City of Portland, Maine - Building or Use Permit Application
 389 Congress Street, 04101 Tel: (207) 874-8703, Fax: (207) 874-8716

Permit No: 06-0712	Issue Date:	CBL: 066A F015001
------------------------------	--------------------	-----------------------------

Past Use: Single Family	Proposed Use: Single Family Interior kitchen renovations	Permit Fee:	Cost of Work: \$0.00	CEO District: 3
Proposed Project Description: Interior kitchen renovations		FIRE DEPT: <input type="checkbox"/> Approved <input type="checkbox"/> Denied	INSPECTION: Use Group: Type	
		Signature:	Signature:	
PEDESTRIAN ACTIVITIES DISTRICT (P.A.D.)				
Action <input type="checkbox"/> Approved <input type="checkbox"/> Approved w/Condition <input type="checkbox"/> Denied				
Signature: Date:

Change of Door and Window

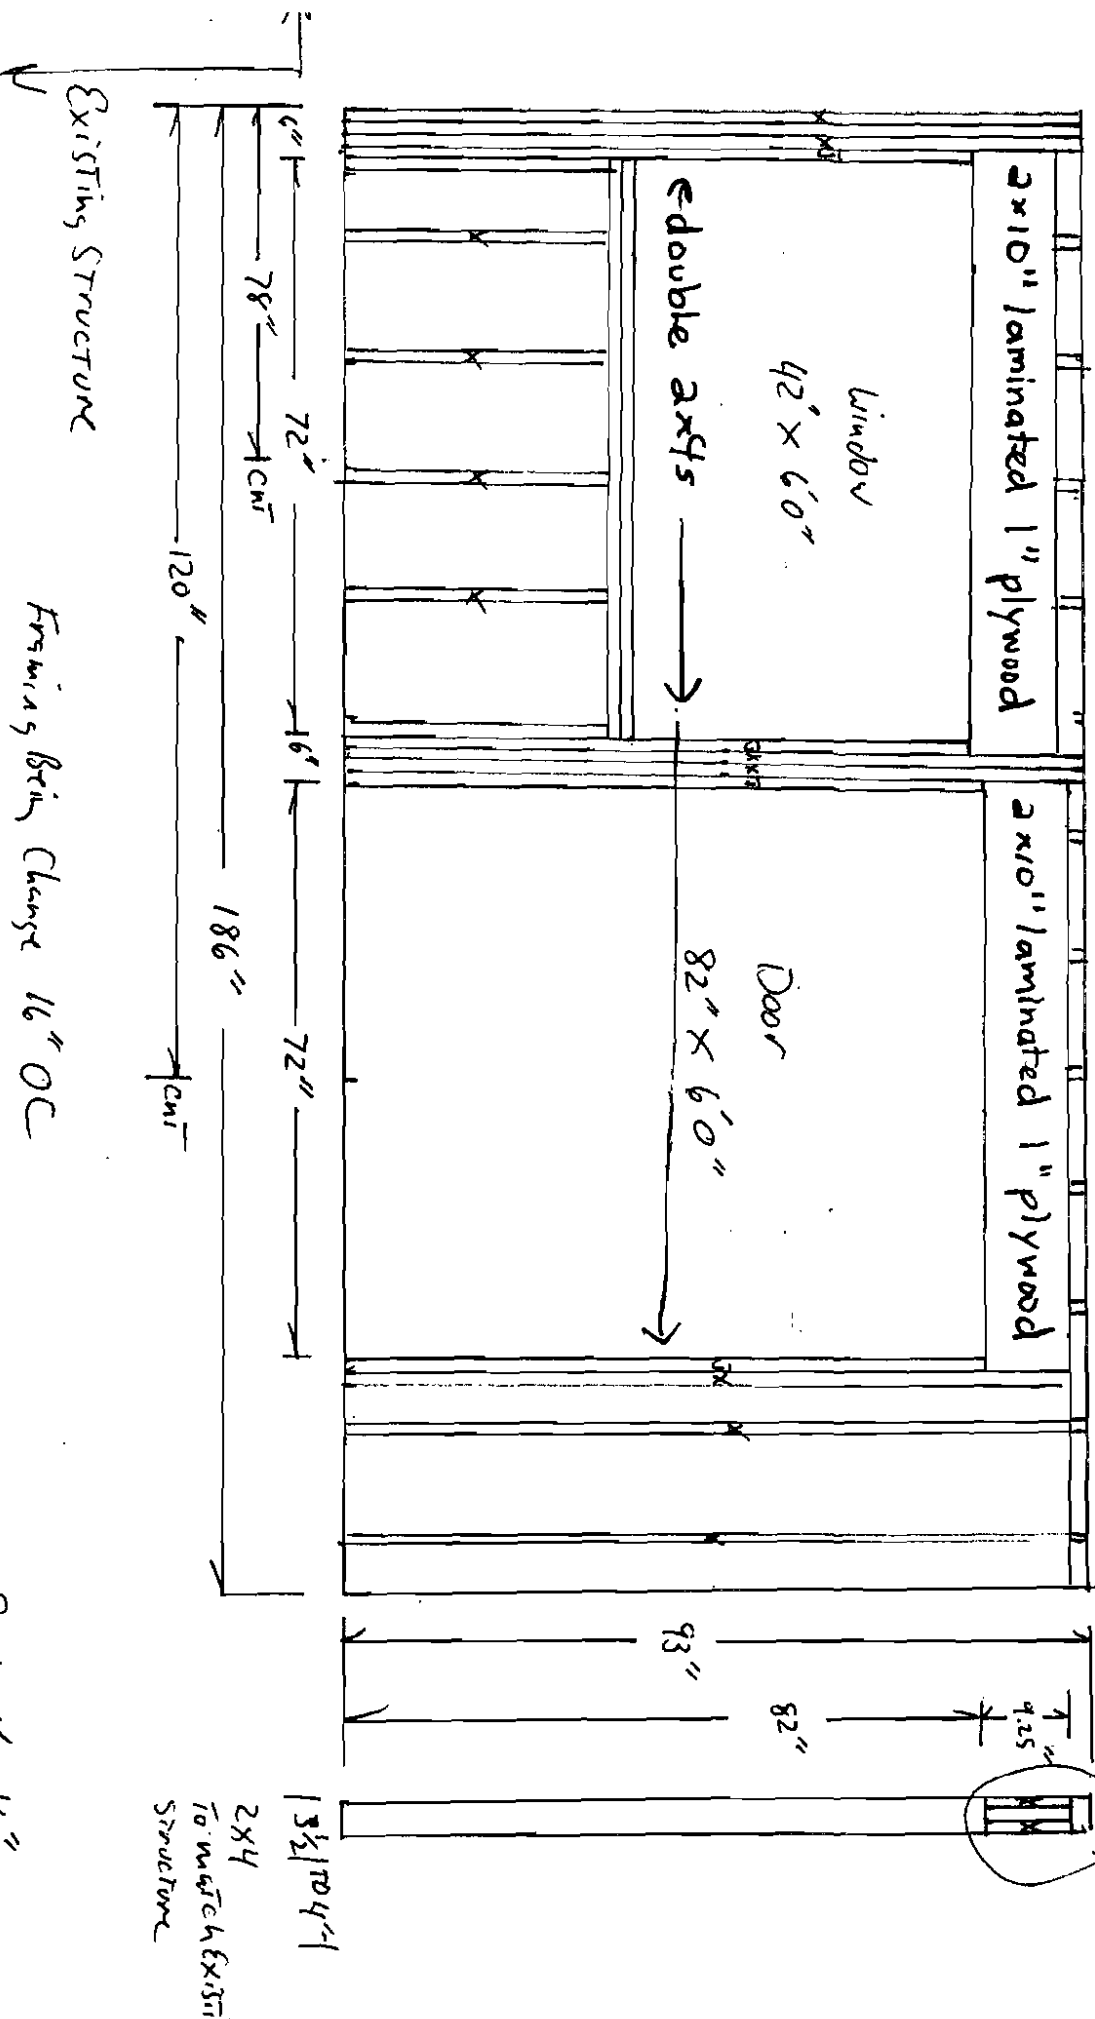
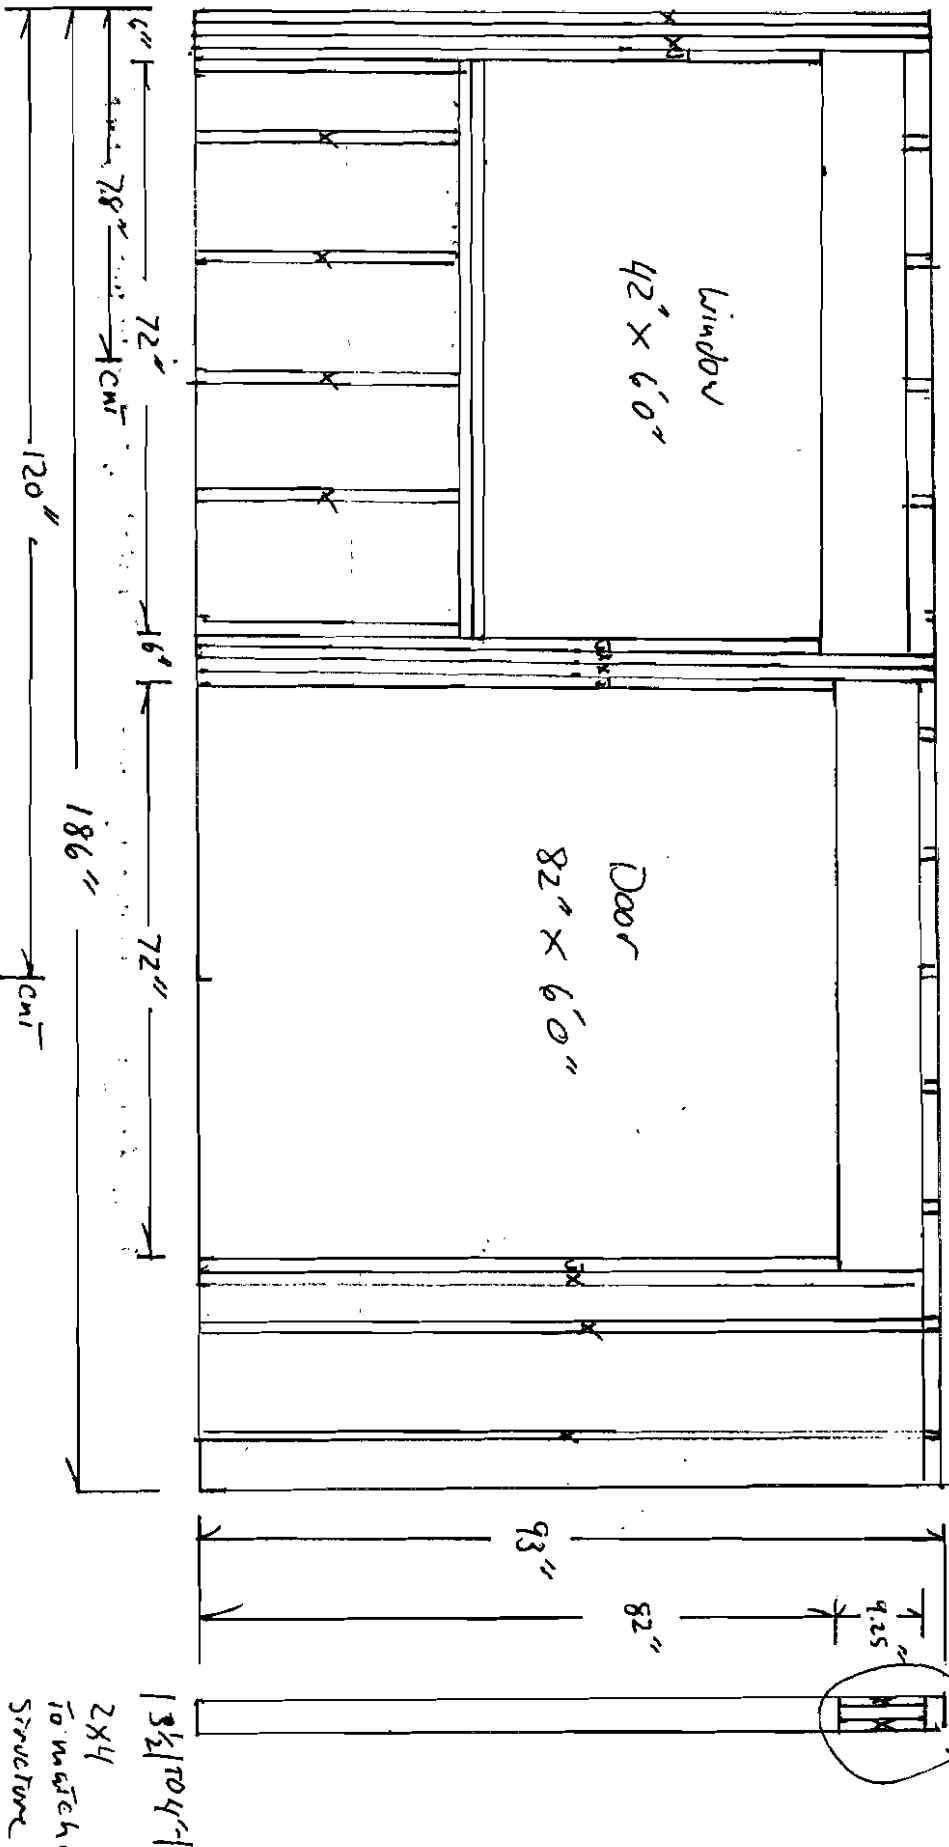
Comments:
6/29/2006-mjn: Left message w/ owner regarding a question about what the slider wioll land on also the 2- 2x 10 headers are underdesigned for this application.

There is only roof load above, meets span tables...OK!
